**KIRKLEES COUNCIL
TOWN AND COUNTRY PLANNING ACT 1990
HIGHWAYS DEVELOPMENT MANAGEMENT**

PLANNING REF 2018/44/90491/W0/VG
CATEGORY Not Req

PROPOSAL DISCHARGE OF CONDITION
3,4,5,8,10,11,12,17,19 ON
PREVIOUS PERMISSION 2014/93584

LOCATION 120 LAUND ROAD
SALENDINE NOOK
HUDDERSFIELD
HD3 3TY

120 LAUND ROAD, SALENDINE NOOK		DRAWN BY MB
SECTION 38 DESIGN AND LONG SECTION		CHECKED BY AH

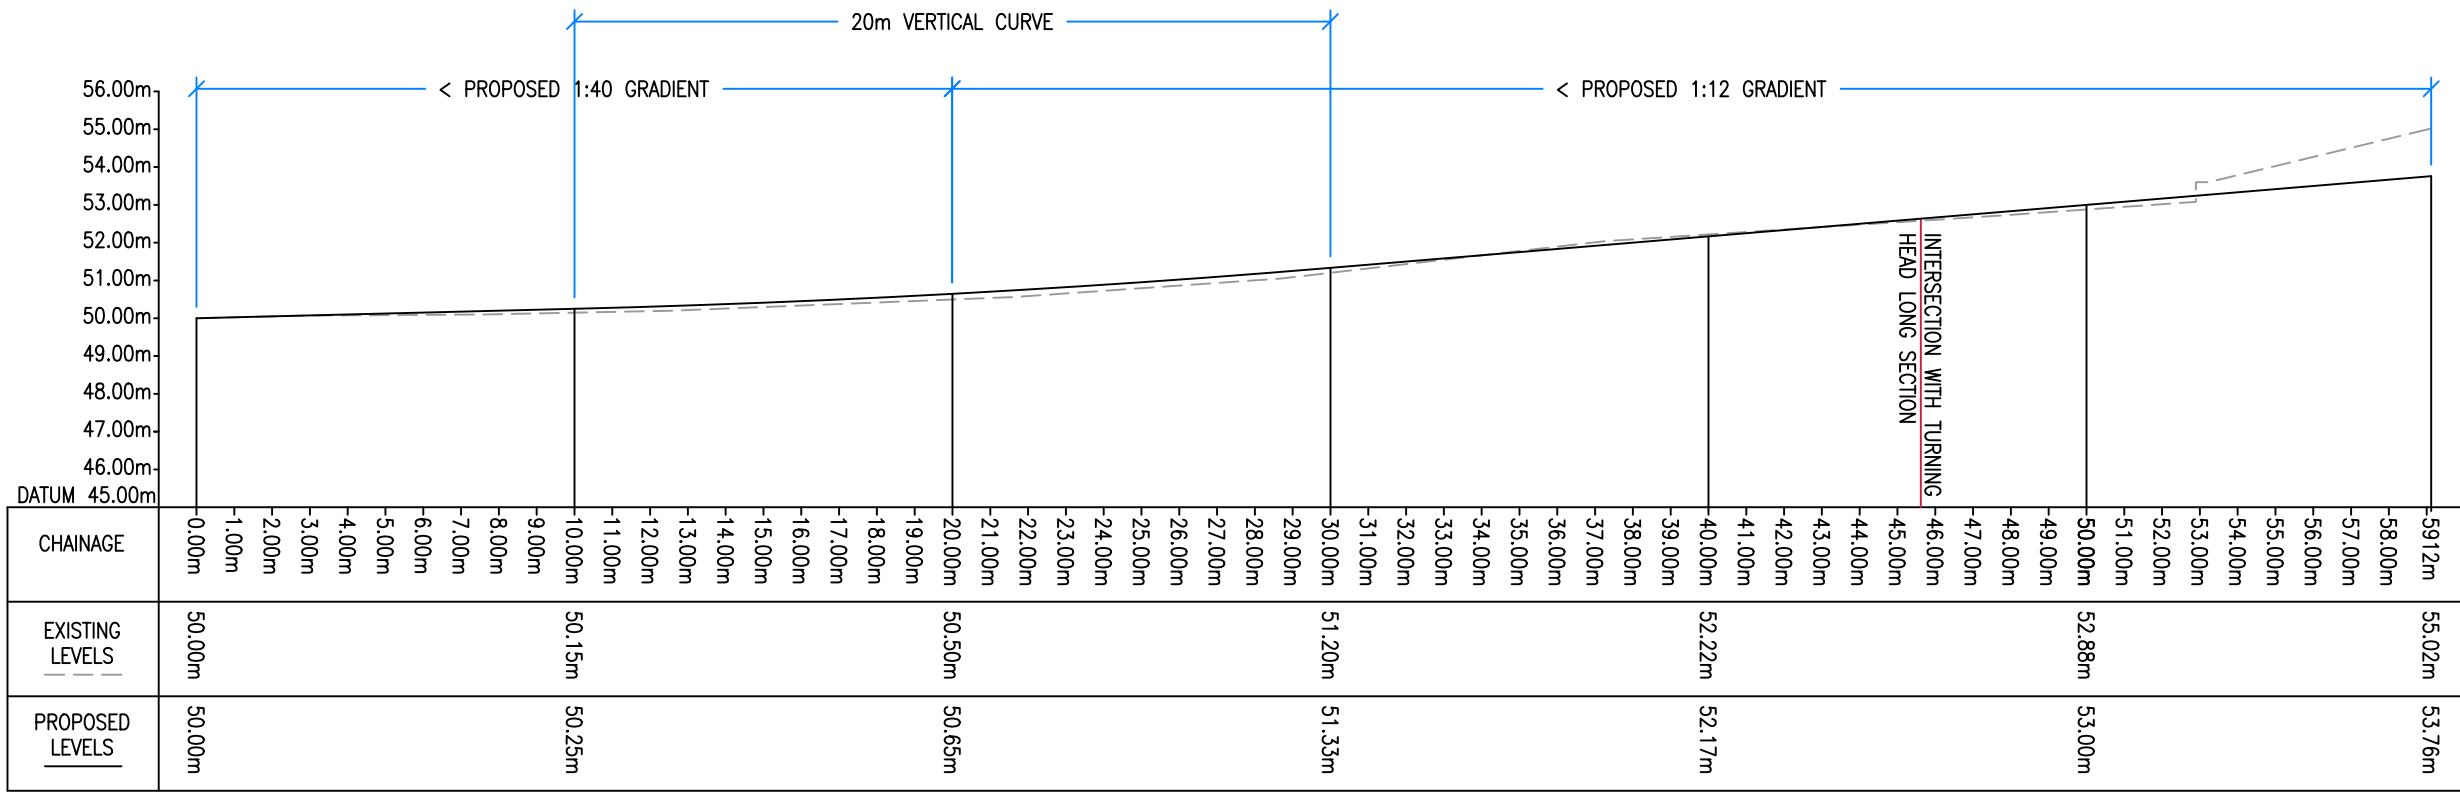
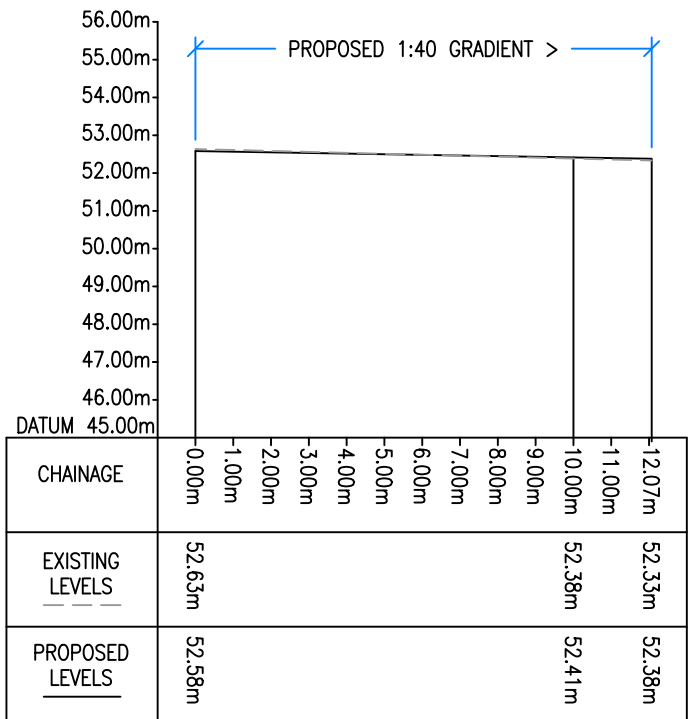
The internal estate road is not to be adopted by the Council, information on the layout has been provided, along with a visibility splay of 2.4m x 43m. It should be noted that this road will not be considered for adoption in the future.
